WHIPPLE-CALLENDER ARCHITECTS

MEMO

RE: Responses to Administrative Review comments for Minor Site Plan Review of 828 Riverside St.

2 D RIPSTRIP FILTER DETAILS

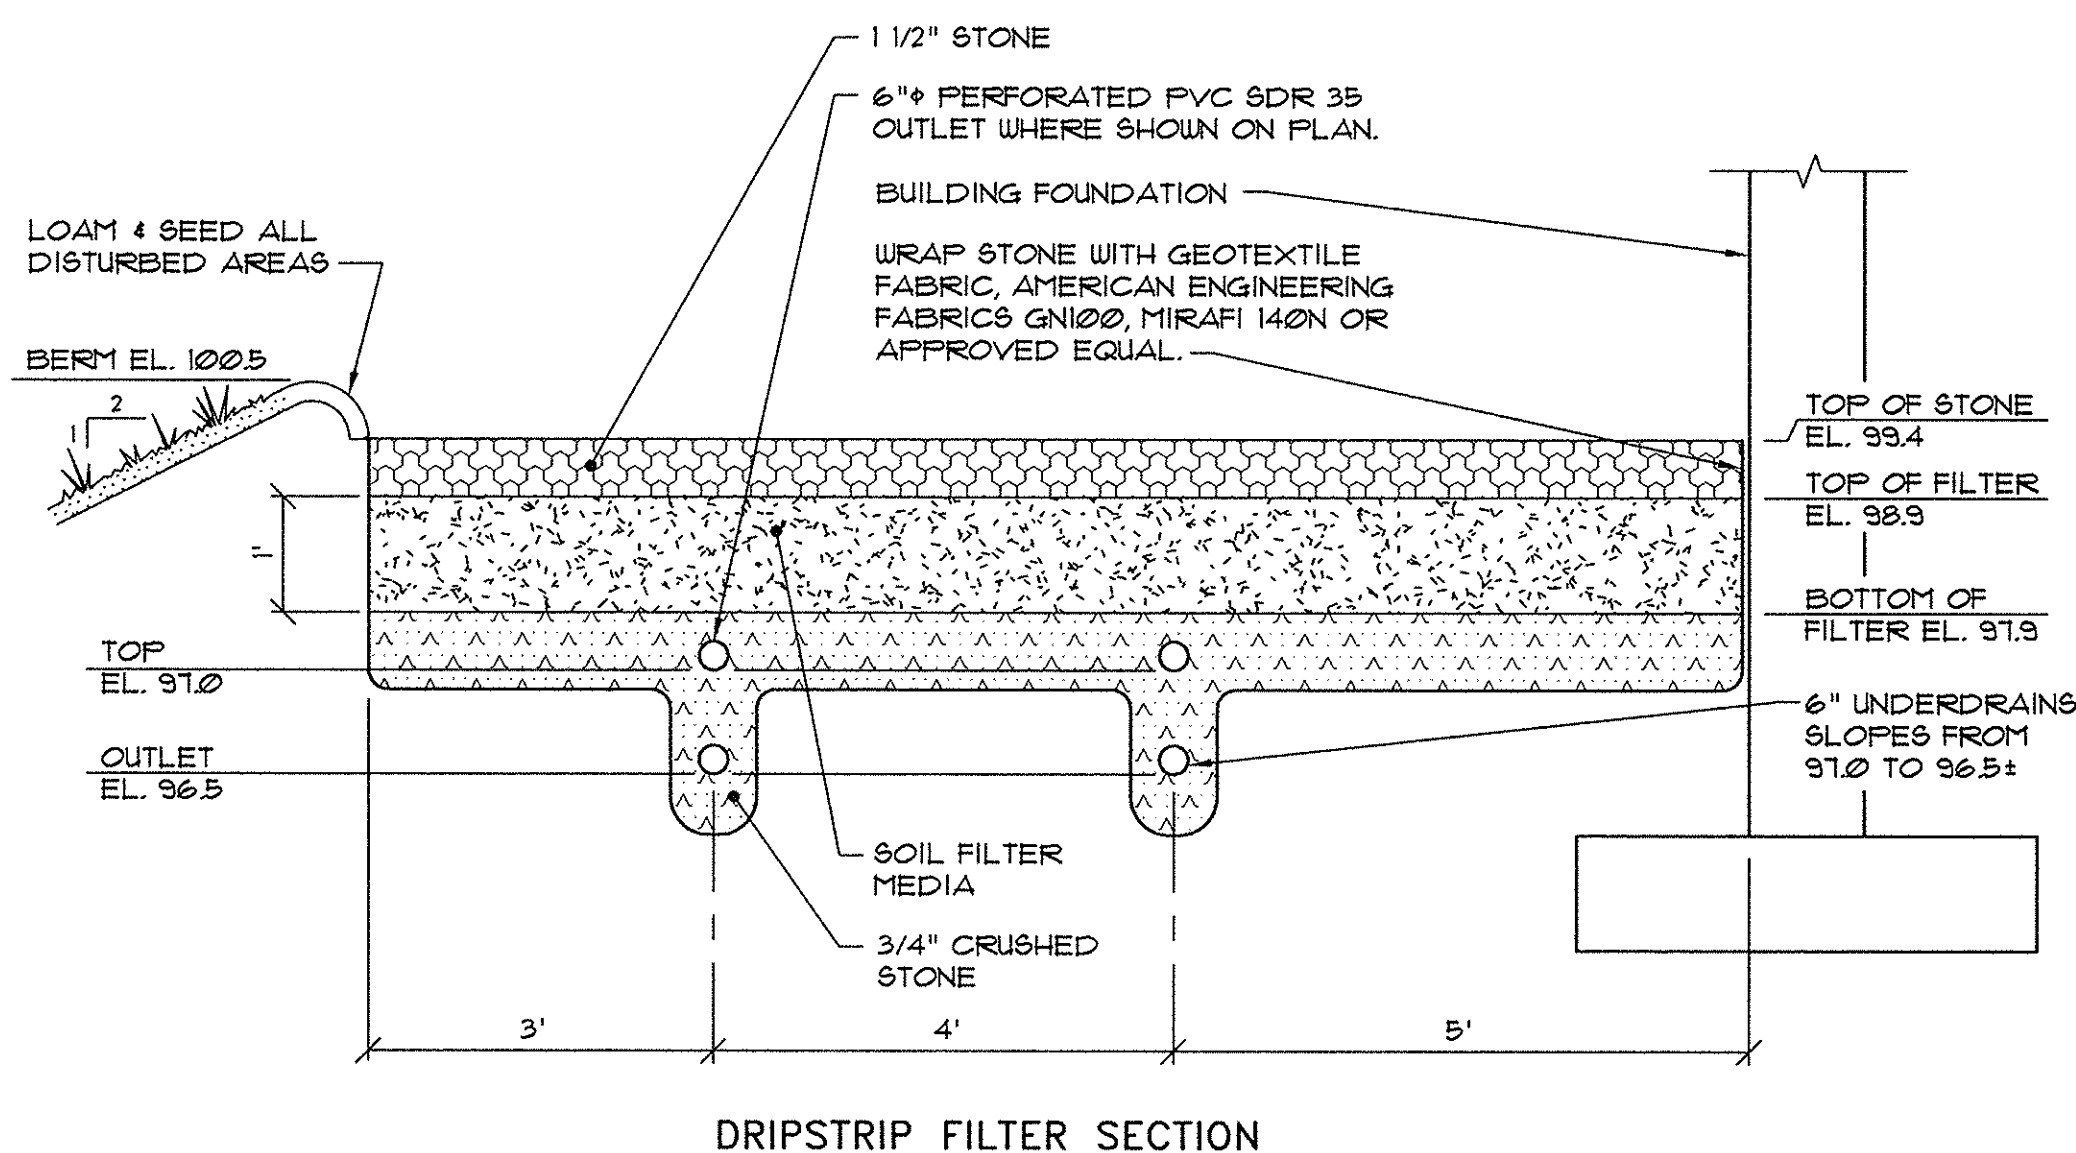
- i **Please refer to the attached Site Plan C-1.1 for stormwater handling. Roof drainage will be directed to a gravel drip strip along the entire east side of the building. From the drip strip, the drainage is conveyed via a swale to a raingarden structure area on the south boundary. Two parking spaces will be concrete pavers and the remainder asphalt. The parking area will drain toward the raingarden and a smaller area will drain to a swale at the north side of the building.**
